CITY OF ALBUQUERQUE

**Re: Restaurant with Drive-thru
1105 Juan Tabo NE
Traffic Circulation Layout
Architect's Stamp XX-XX-XX (J21-D024)**

TRAFFIC CIRCULATION LAYOUT - PROPOSED  
Drawing No. TC1.1

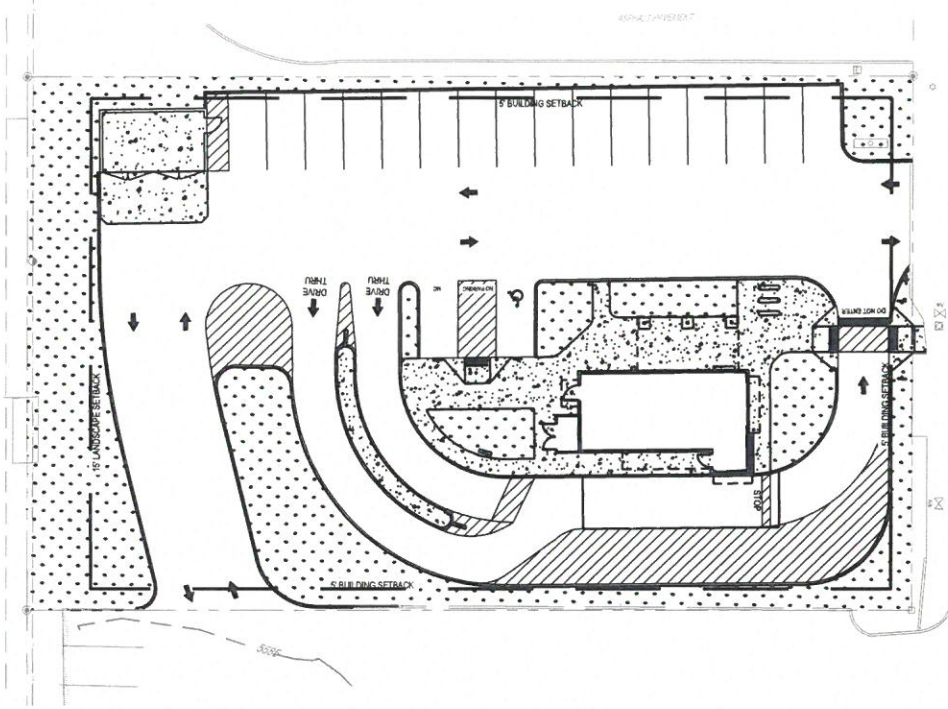
1. An Architect or Engineer's stamp is required on all sheets of Site Plan requiring approval.
2. Trip Generation(Restaurant with drive-thru): Was this accomplished for comparison of existing status versus proposed to determine if a TIS is required?
3. Please coordinate all calculations for parking spaces, including bicycle, and motorcycle parking with Zoning. List the number of parking spaces required by the zoning code as well as the proposed number of parking spaces including bicycle and motorcycle parking.
4. Please show a vicinity map with Zone Atlas number
5. Identify all existing access easements and rights of way width dimensions.
6. Identify the right of way width, medians, curb cuts, and street widths on Juan Tabo NE.
7. Maximum access width for arterial (**Juan Tabo NE**), collector, and local streets are as follows:

(WB-40) Turning movements are overlapping onto Juan Tabo driving lanes and encompassing all the ingress and egress at entrance. Maybe a larger entrance would alleviate these conflicts of delivery and passenger vehicle usage of Site entrance. The overlapping of WB-40 onto driving lanes will need to be addressed.

14. A 1-foot clear zone around the bicycle parking stall shall be provided.
15. Bicycle parking spaces shall be at least 6 feet long and 2 feet wide.
16. Show all drive aisle widths. Some dimensions are not shown.

17. Radius for delivery trucks, fire trucks, etc. is 25 ft. or larger.

20. Provide a copy of refuse approval.
21. The minimum drive through lane width is 12 feet with a 25 foot minimum radius (inside edge) for all turns, including existing. (A 15 foot radius can be used with an increase in lane width to 14 feet).

22. Shared Site access (**WB-40 traversing thru adjacent property**): driveways that straddle property lines, or are entirely on one property but are to be used by another property, shall have an access easement. Please include a copy of your shared access agreement with the adjacent property owner.

**HANDICAPPED PARKING SIGNAGE DETAIL**  
NOT TO SCALE

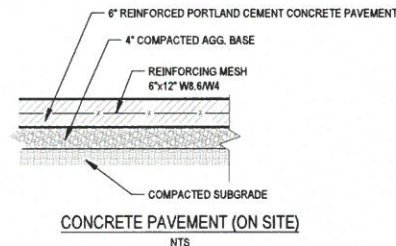
9. The ADA access aisles shall have the words **"NO PARKING"** in capital letters, each of which shall be at least one foot high and at least two inches wide, placed at the rear of the parking space so as to be close to where an adjacent vehicle's rear tire would be placed. (66-1-4.1.B NMSA 1978)

**INVERTED U BICYCLE RACK DETAIL**  
NTS

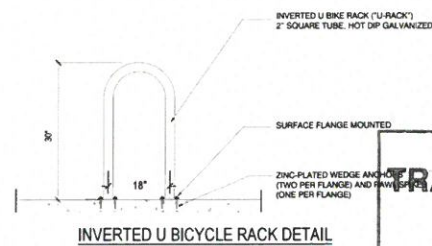
12. All bicycle racks shall be designed according to the following guidelines:
- The rack shall be a minimum 30 inches tall and 18 inches wide.
 - The bicycle frame shall be supported horizontally at two or more places. Comb/toaster racks are not allowed.

- The rack shall be designed to support the bicycle in an upright position. See the IDO for additional information.
 - The rack allows varying bicycle frame sizes and styles to be attached.

- The user is not required to lift the bicycle onto the bicycle rack.
 - Each bicycle parking space is accessible without moving another bicycle.
13. Bicycle racks shall be sturdy and anchored to a concrete pad.

**DETECTABLE WARNING MAT DETAIL**  
NOT TO SCALE

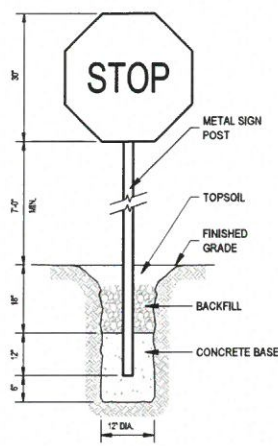
10. ADA curb ramps must be updated to current standards and have truncated domes installed.
11. Label pavement MC for all proposed Motorcycle parking stalls.
